186827 PA/2016/649 Creation of habitat, Halton Marshes

Date: 09 September 2016
Our ref: 193994
Your ref: PA/2016/649

**Planning consultation: Planning permission for creation of habitat, primarily wet grassland
Location: Land to the East of Skitter Road, Halton Marshes, East Halton**

Revision Details		By	Chk	Date	Suffix
Drawing Number		Revision			
NABL 104/12597/1

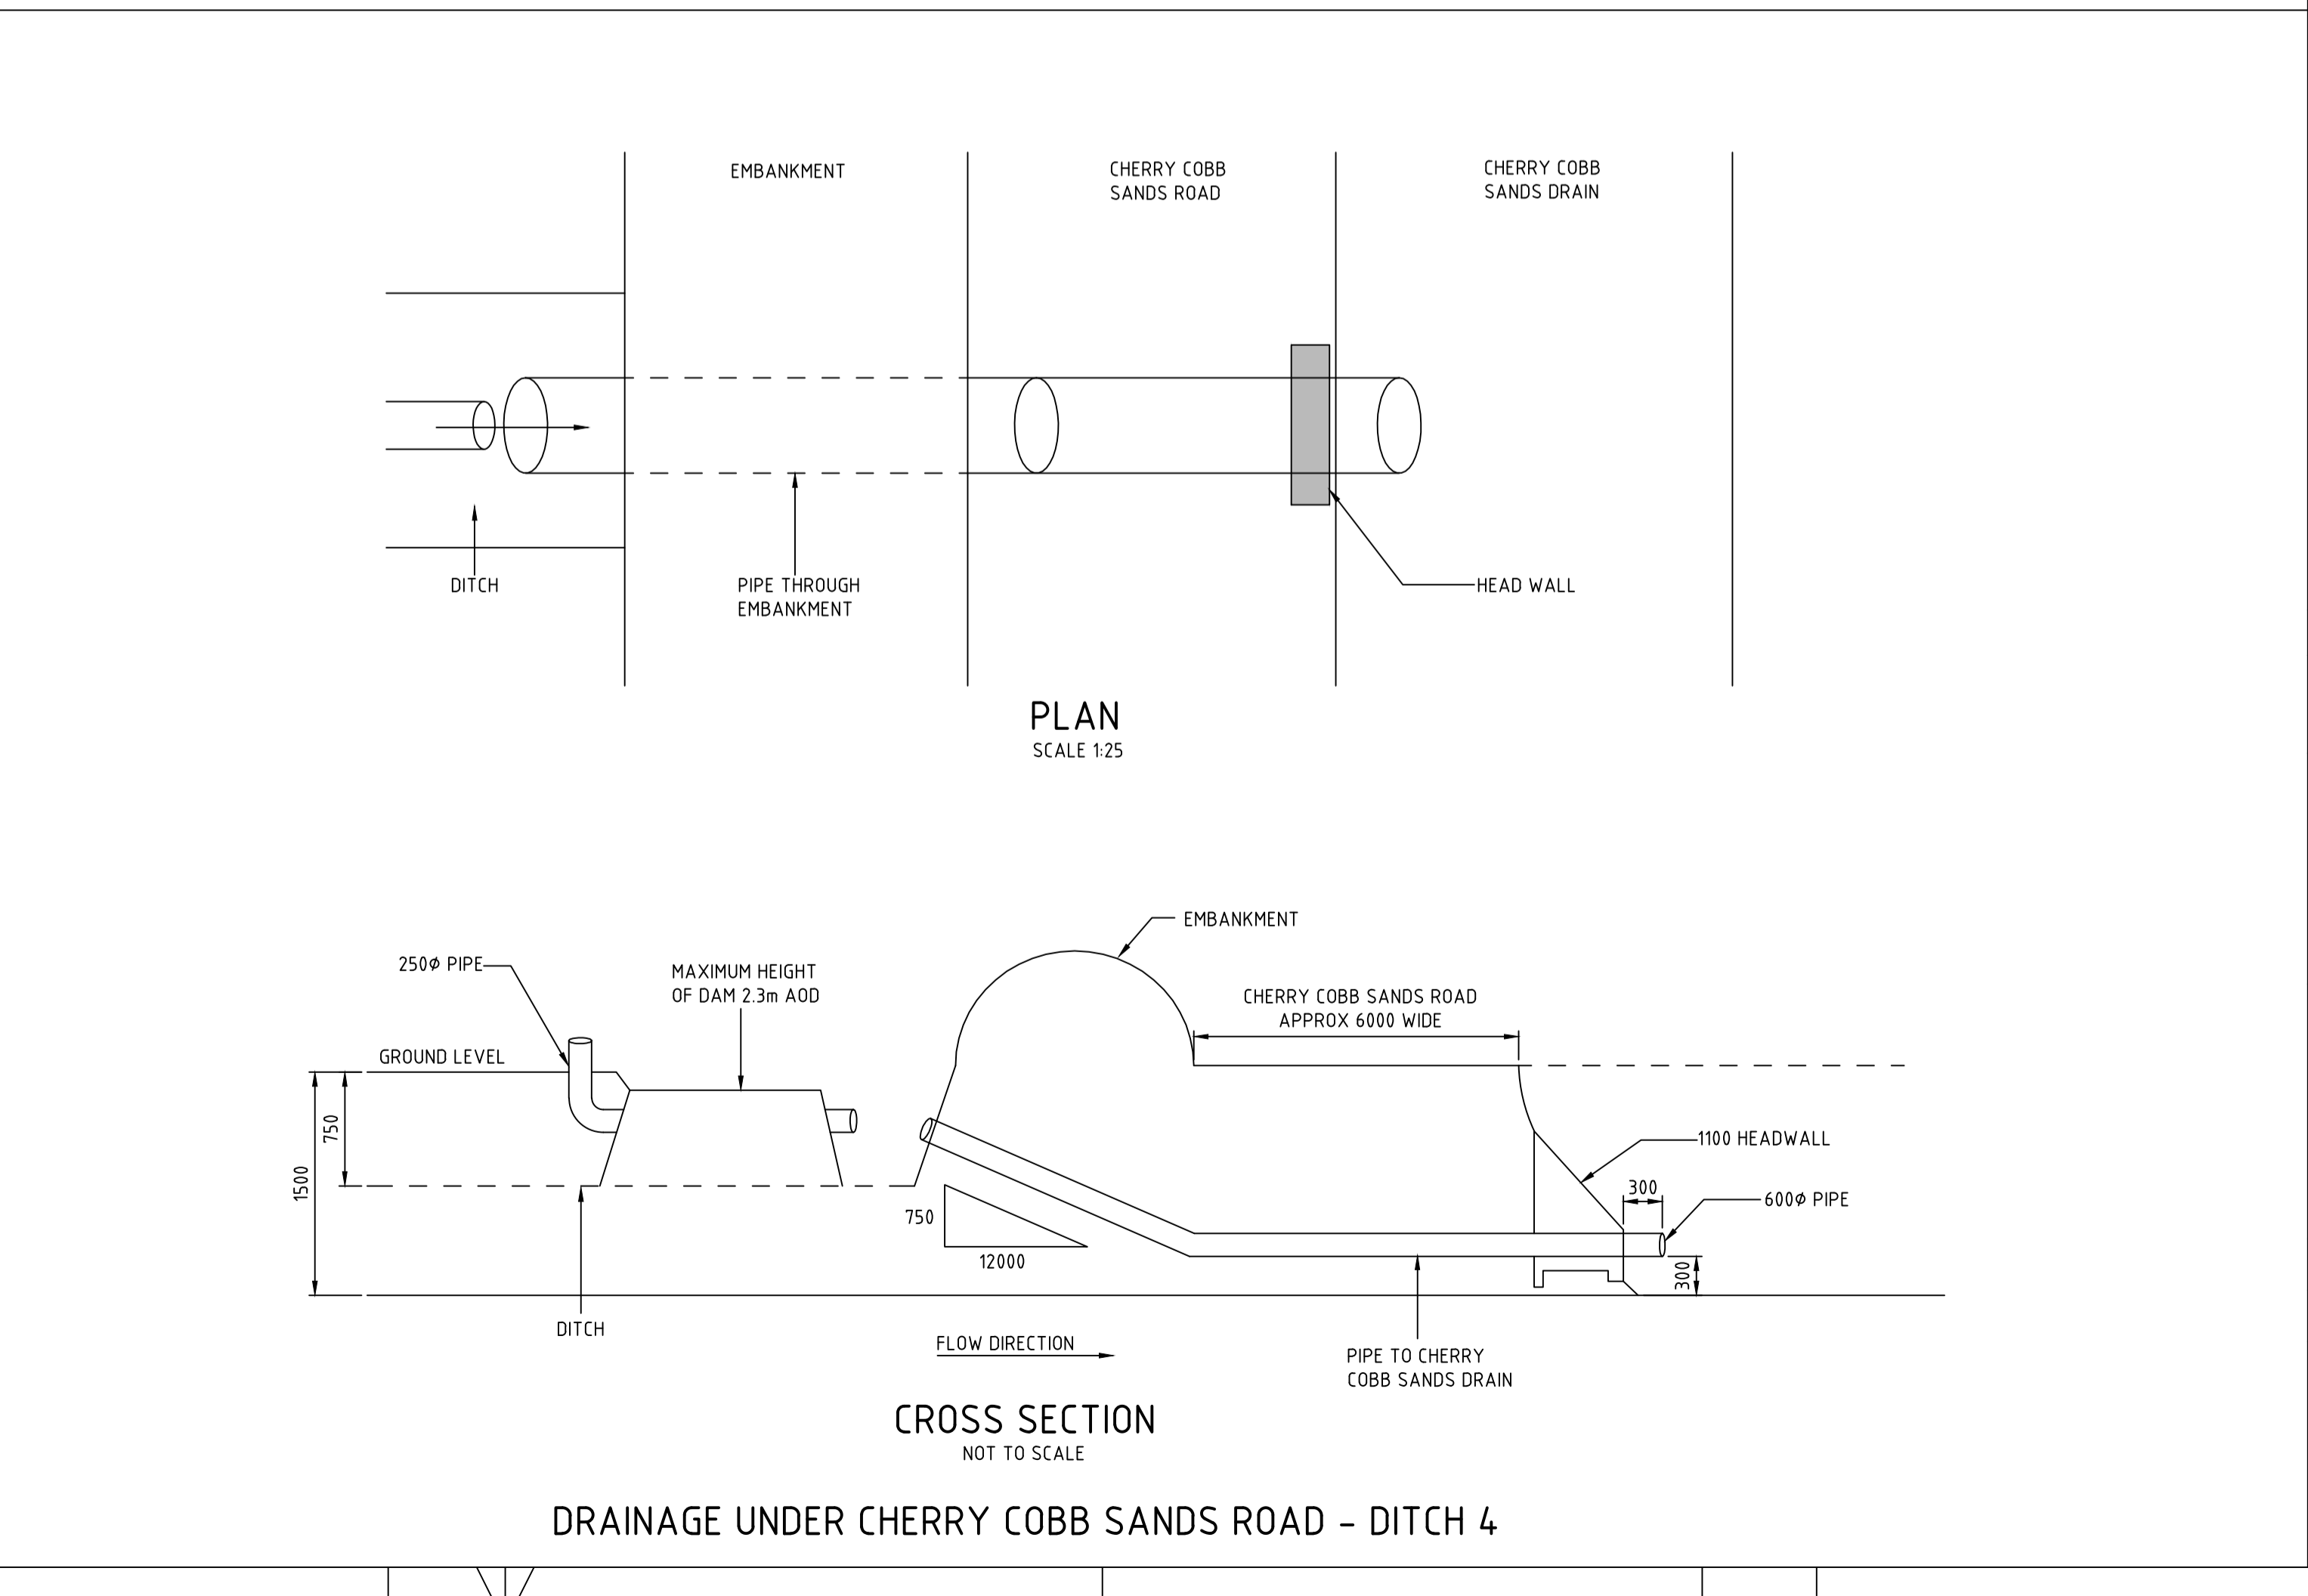
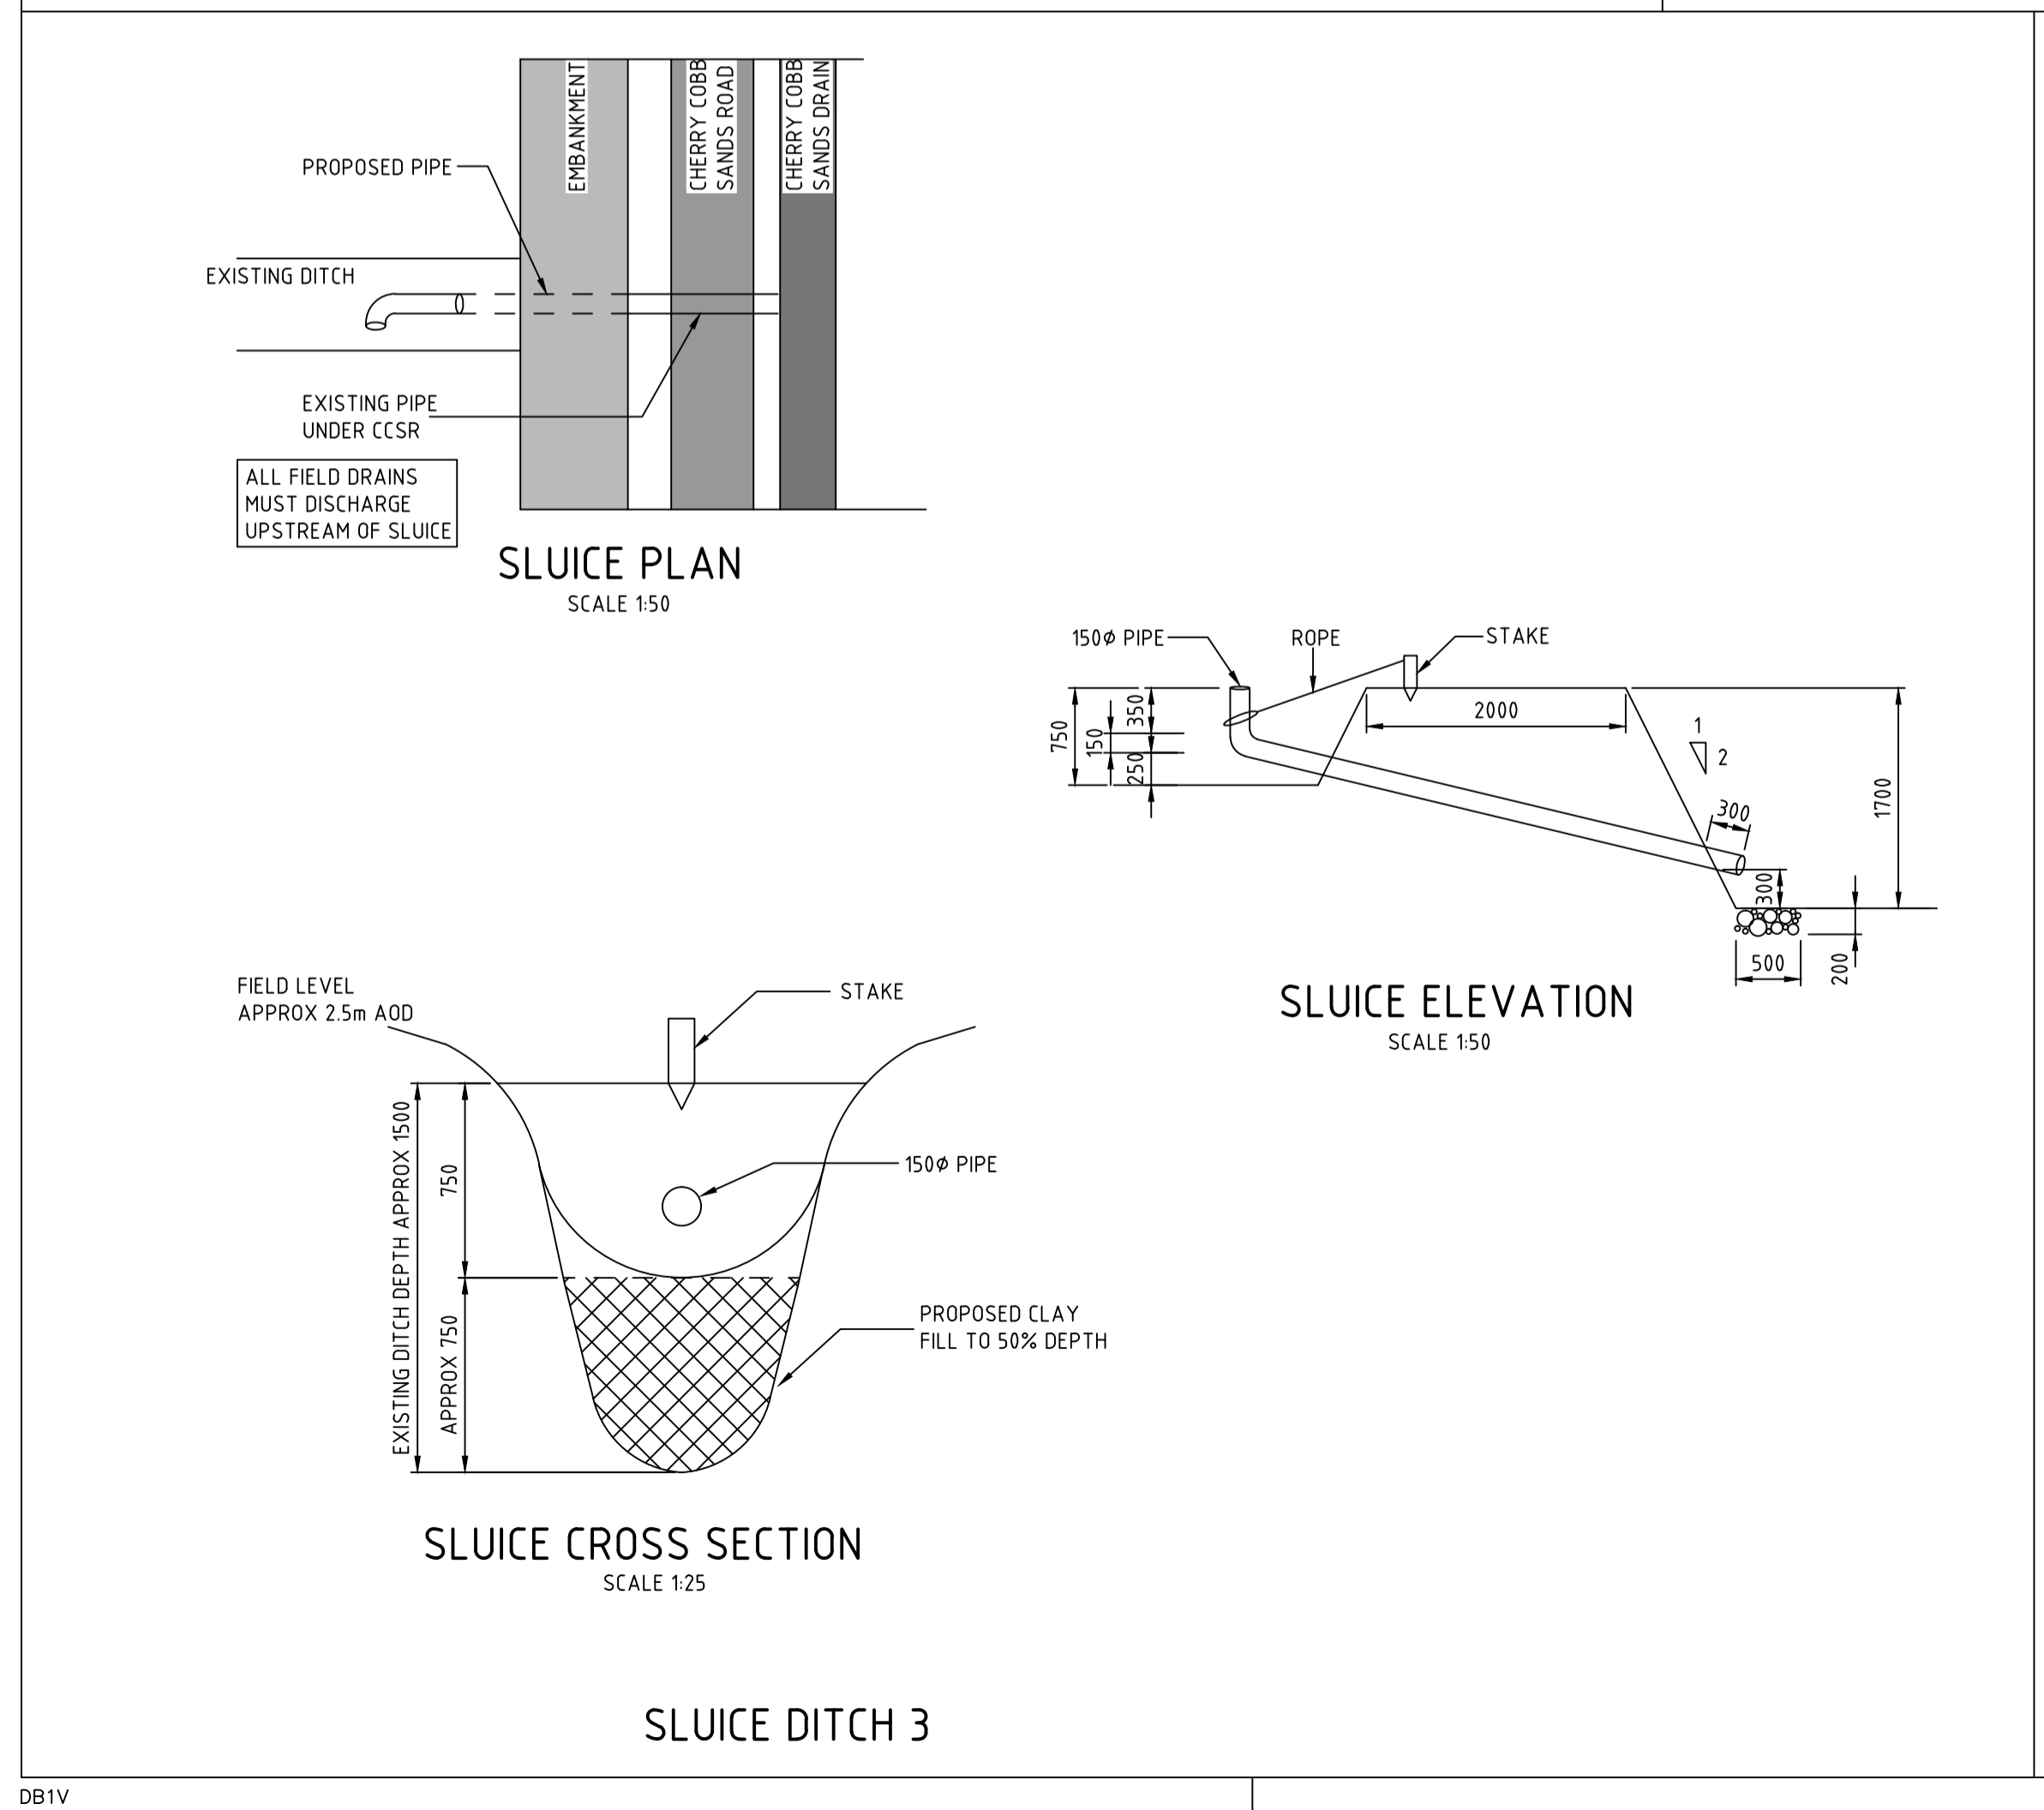
- It would be helpful if the location of the wind pump could be shown on this drawing and all other relevant drawings.
